Your Ref: SSD-9601

SSD-9601 – 780 WALLGROVE ROAD, HORSLEY PARK – PROPOSED UPGRADES TO PLANT 2 – RESPONSE TO SUBMISSION

ATTACHMENT A – DEVELOPMENT ENGINEER CONDITIONS

info@asongroup.com.au

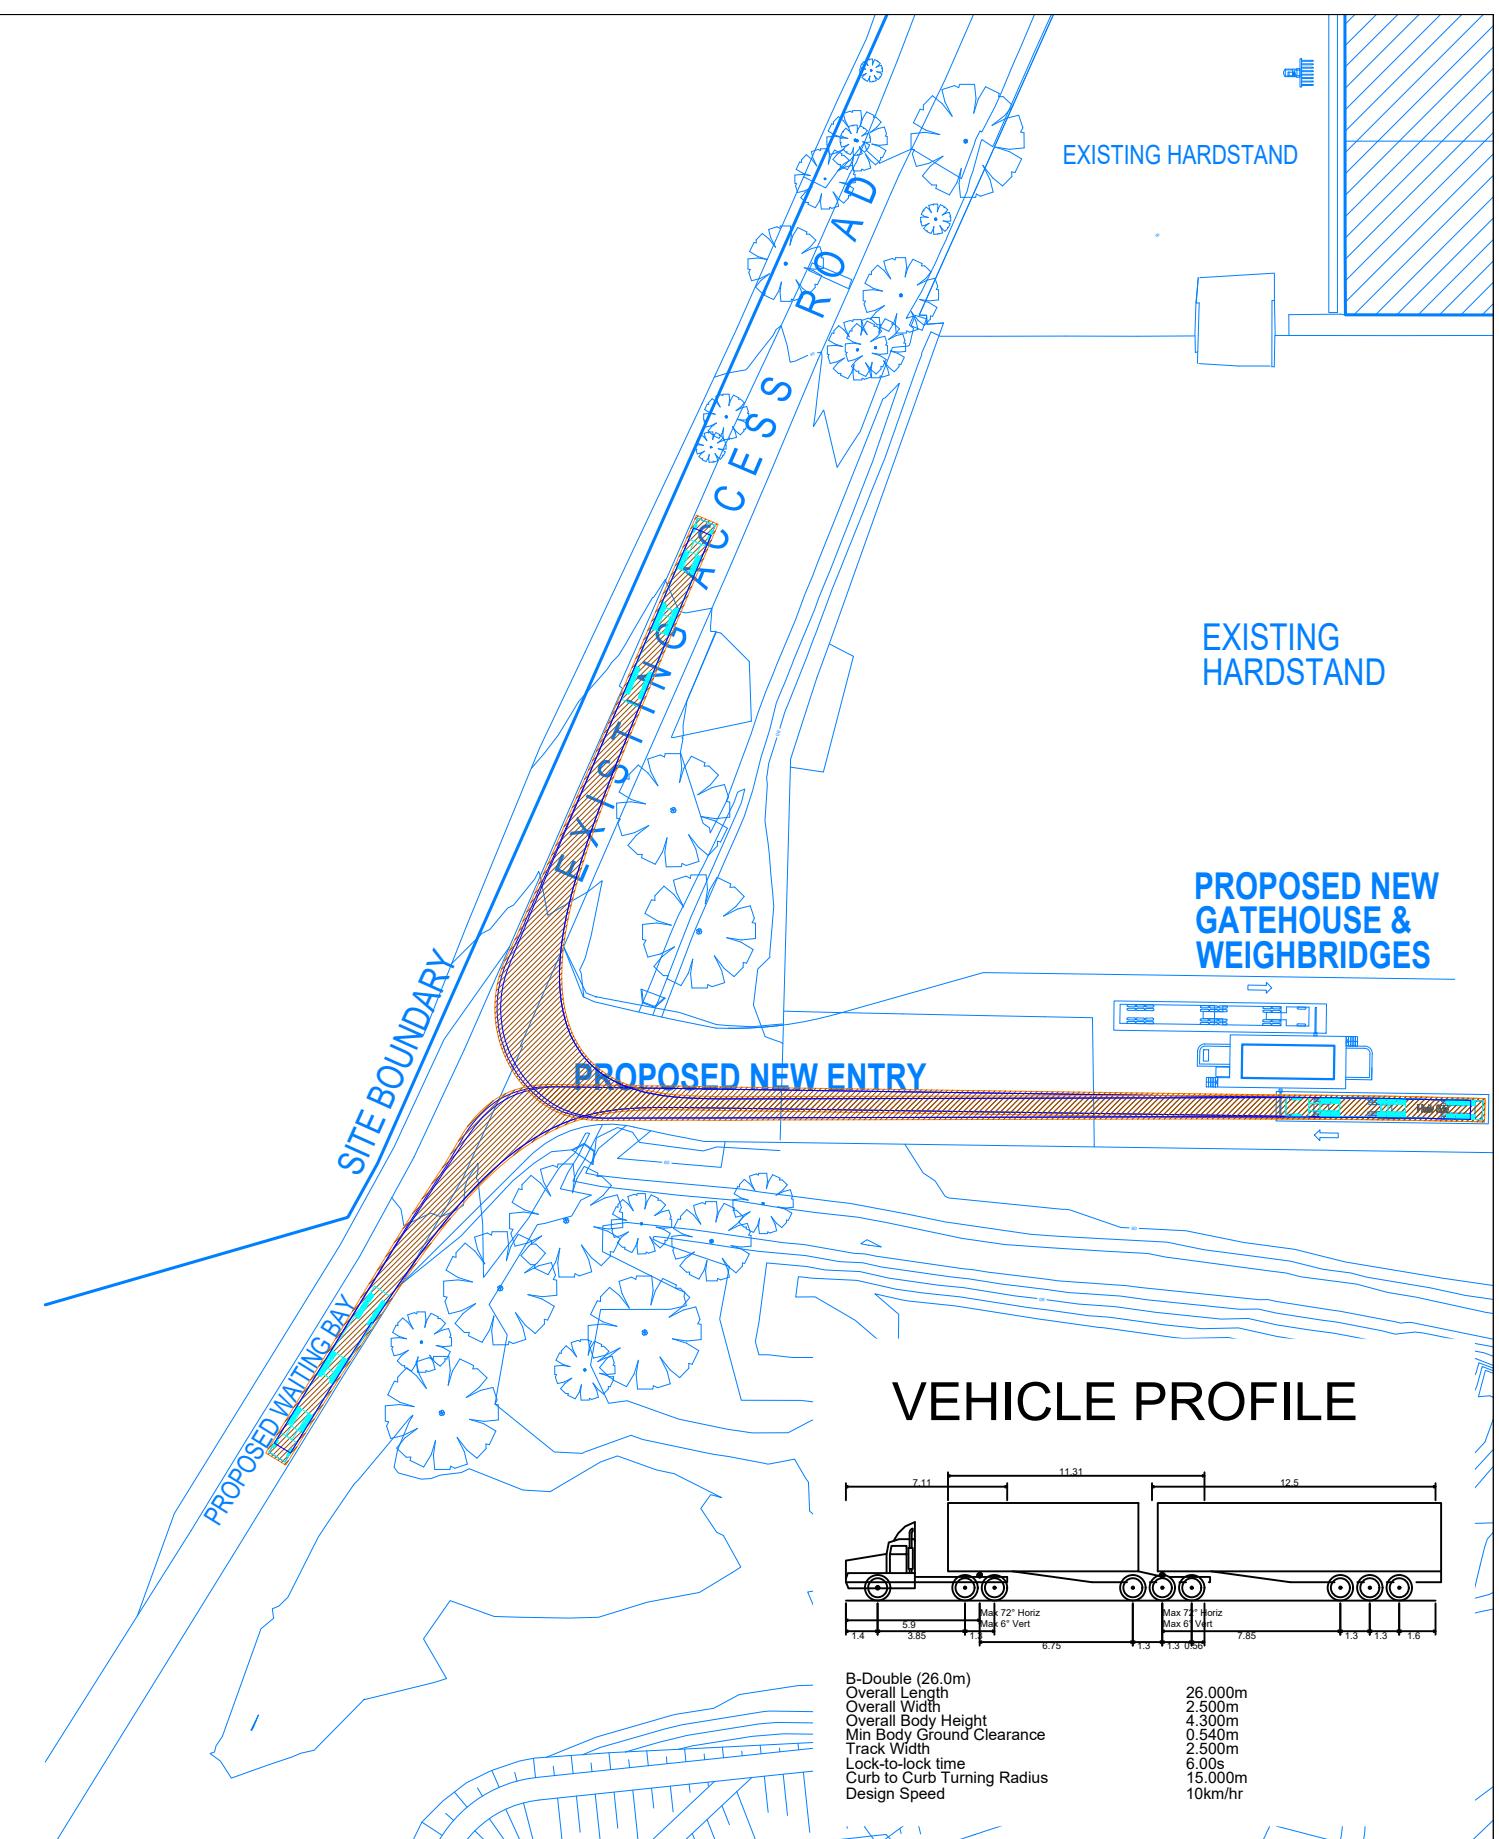
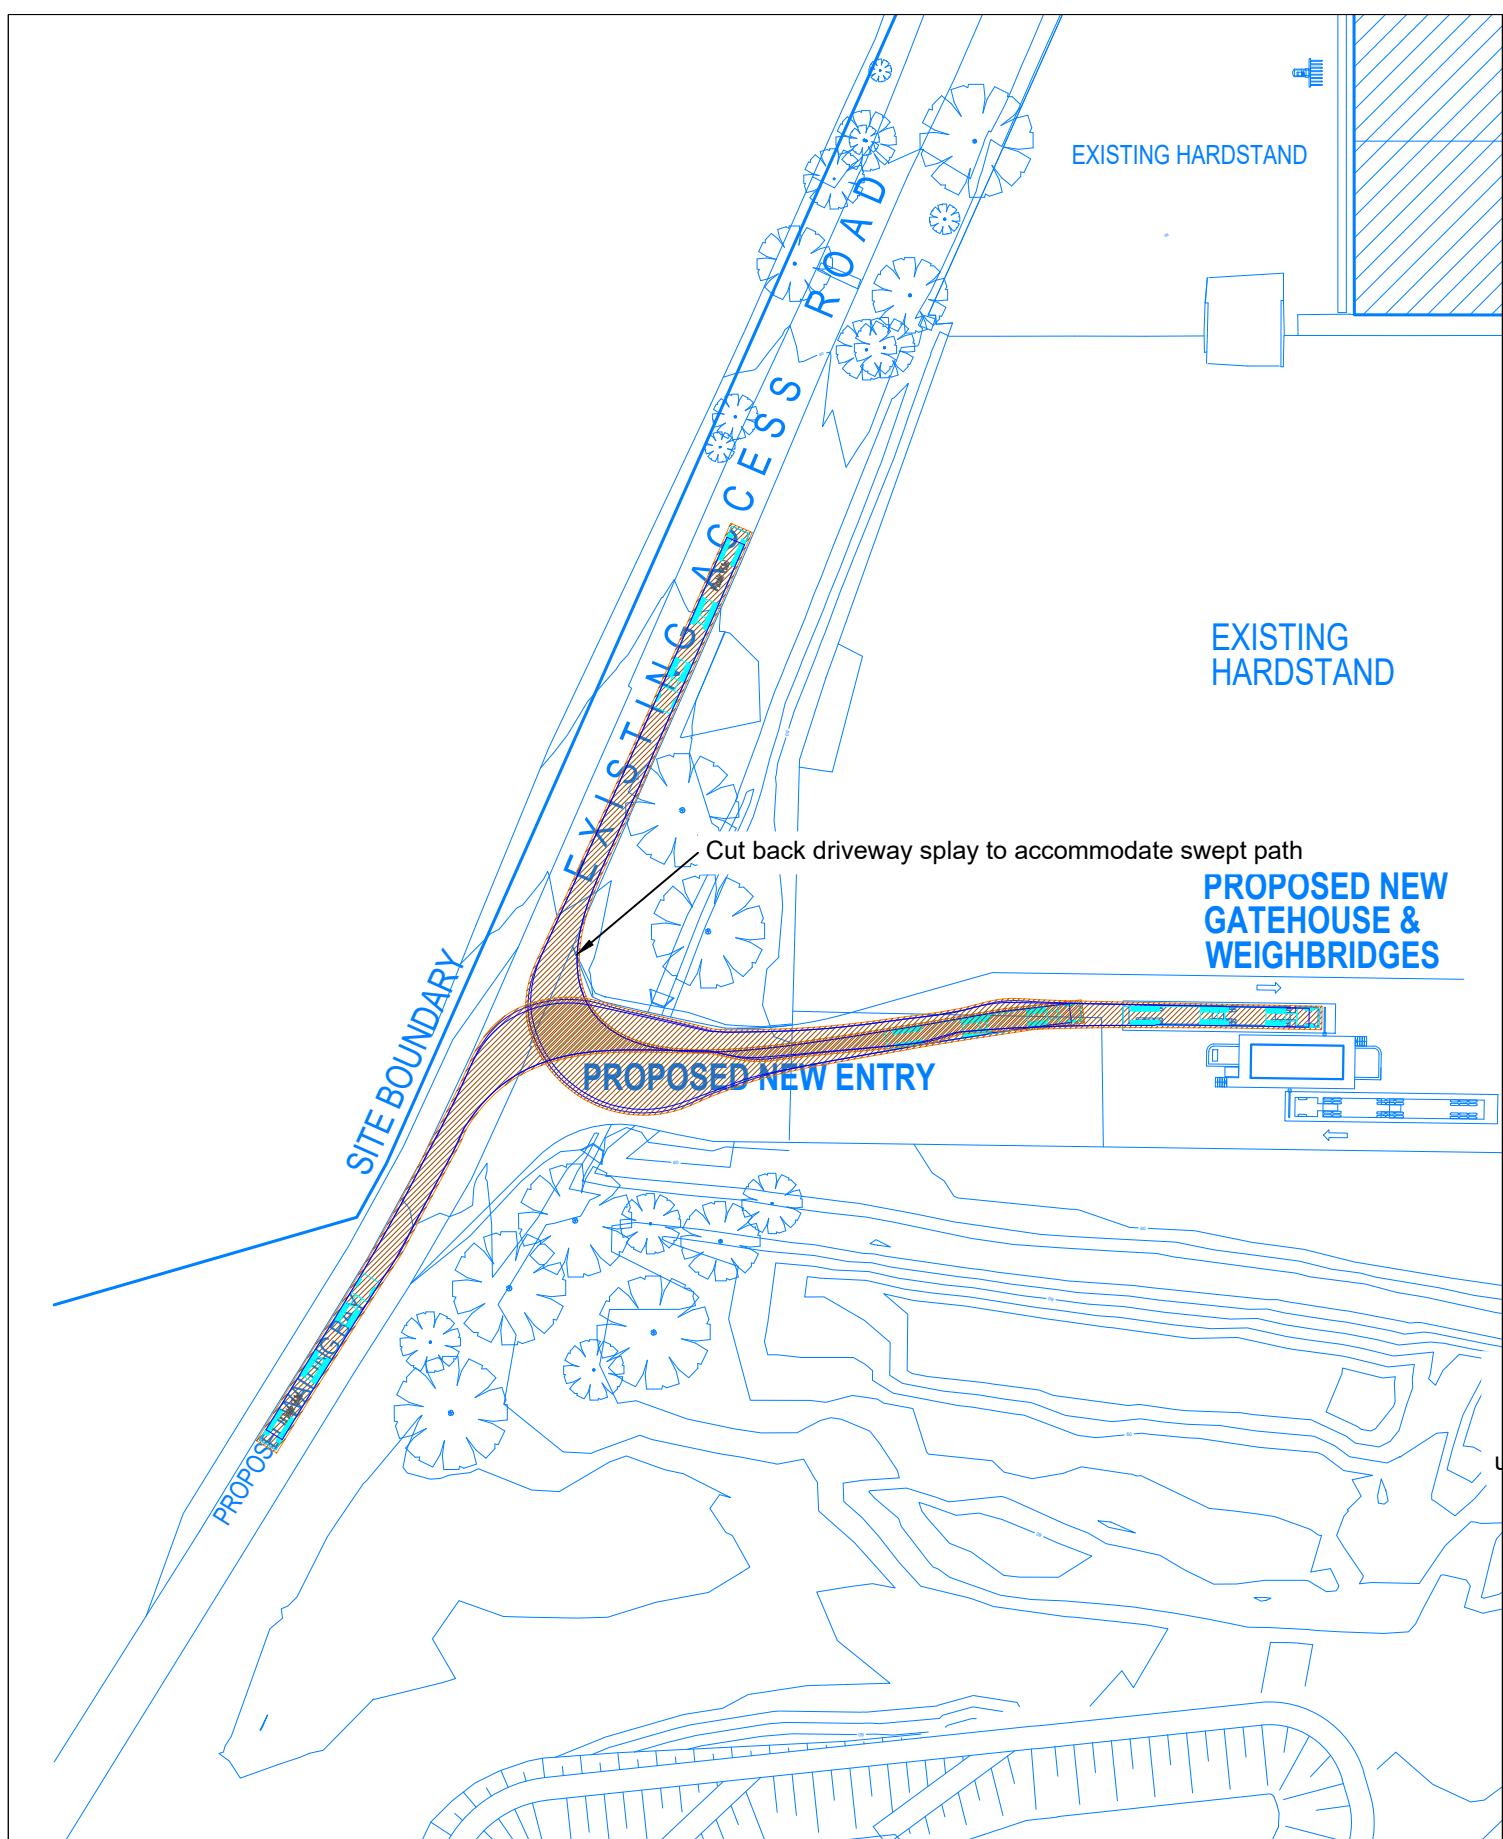
The proponent previously indicated that the largest vehicle servicing the subject site is a 26m B-Double vehicle. To ensure the servicing vehicle will not obstruct car parking areas and flow of traffic within the site, the proponent shall submit a turning path analysis showing the largest vehicle (26m B-Double vehicle) manoeuvring into, within and out of the site shall be submitted to Council for assessment.

The largest vehicle (26m B-Double vehicle) shall carry out loading and unloading activities from the designated loading areas and shall not obstruct car parking areas and the flow of traffic within the site.

Council requires further clarification regarding where the 26m B-Double vehicles will carry out loading and unloading activities on-site, with details to be submitted to Council's satisfaction prior to the commencement of construction activities.
